PRELIMINARY PLAN
FOR
VIEWPOINT ESTATES FILING NO. 2

PORTION OF SECTION 10, TOWNSHIP 14 SOUTH, RANGE 63 WEST OF THE 6TH PRINCIPAL MERIDIAN
EL PASO COUNTY, COLORADO

MVE PROJECT:
61099
MVE DRAWING:
PRELIM-CS
DATE:
NOVEMBER 8, 2021
SHEET:
SHEET 1 OF 1

PRELIMINARY PLAN FOR LOT 71

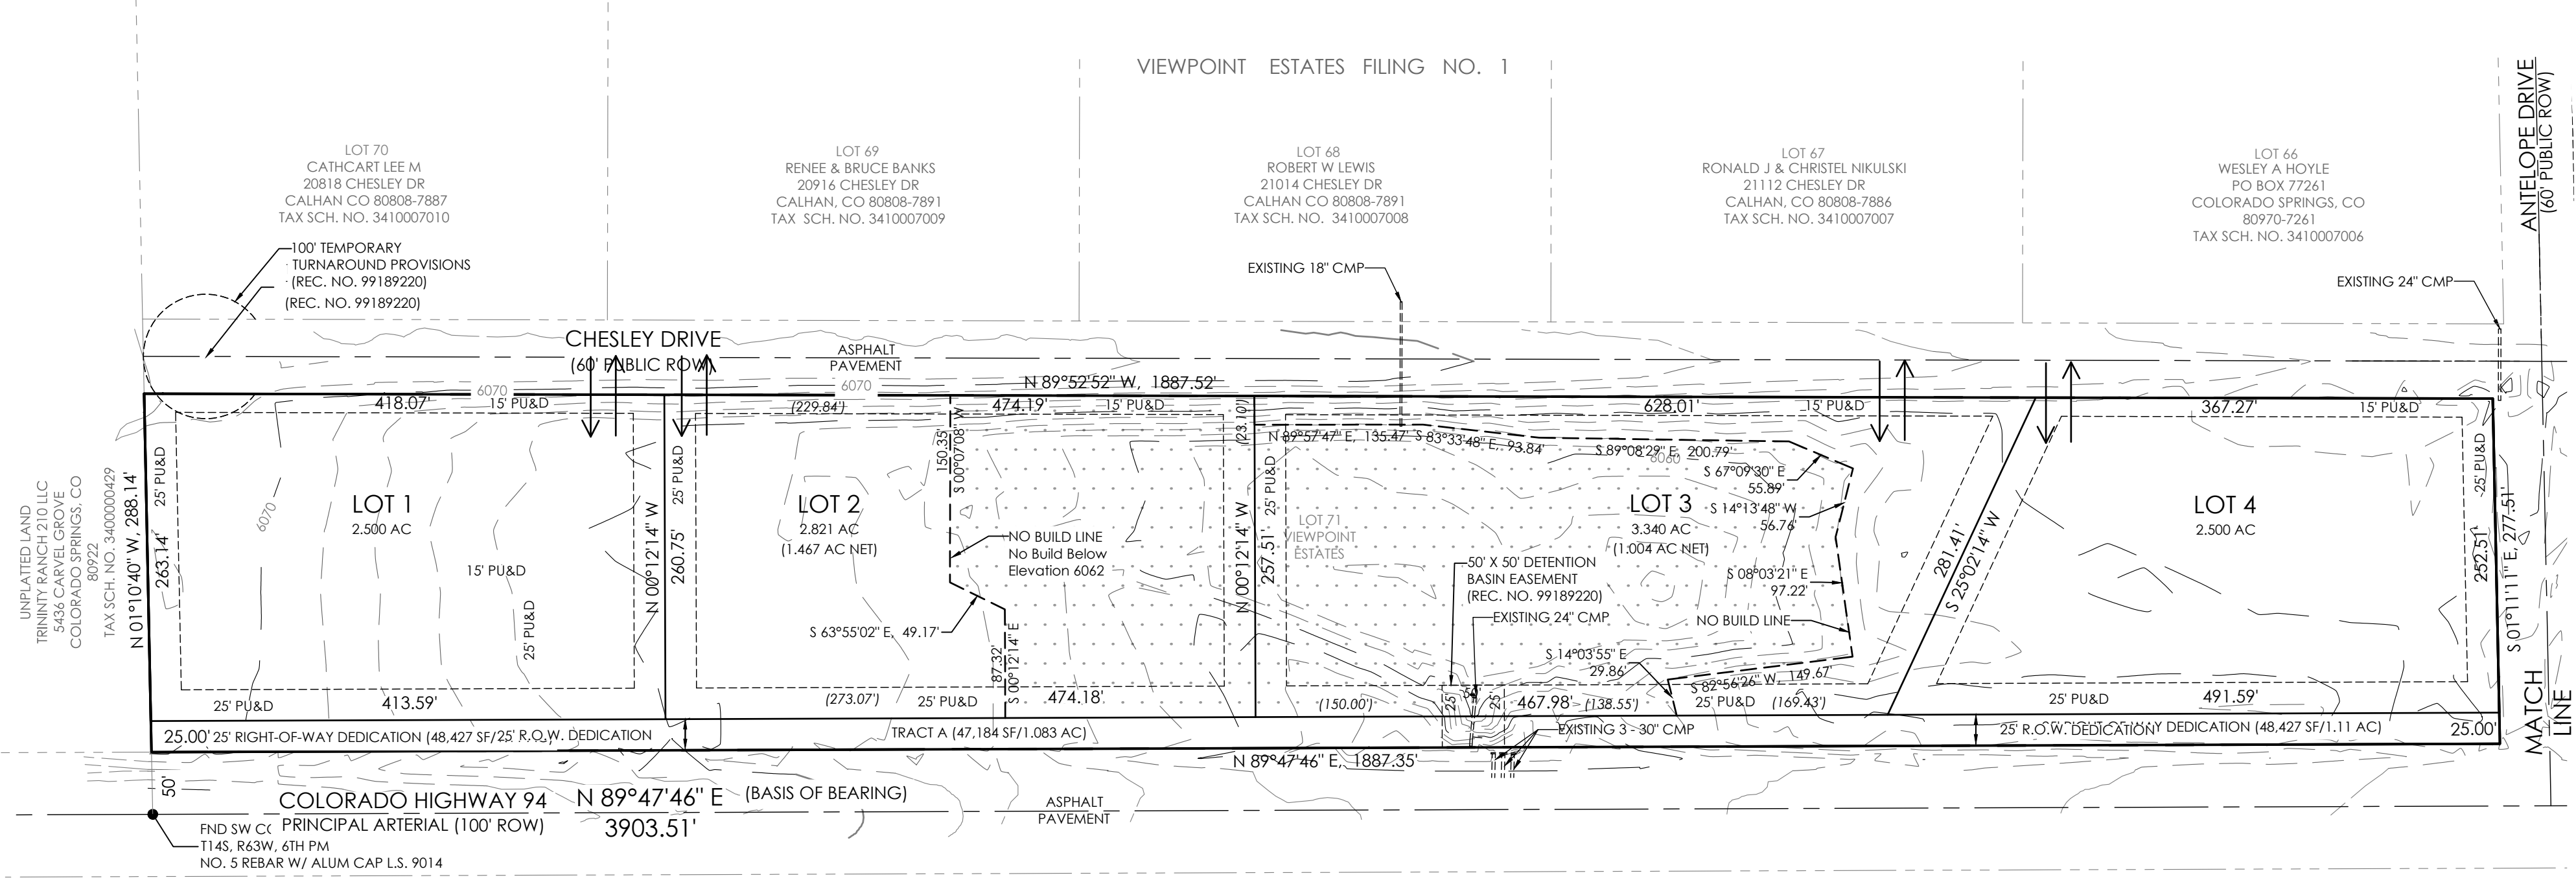
Include roadway classification

Add bearings on all interior lot lines and easements

Is this lot still buildable?

Add no build below elevations for both Lot 71 & 72
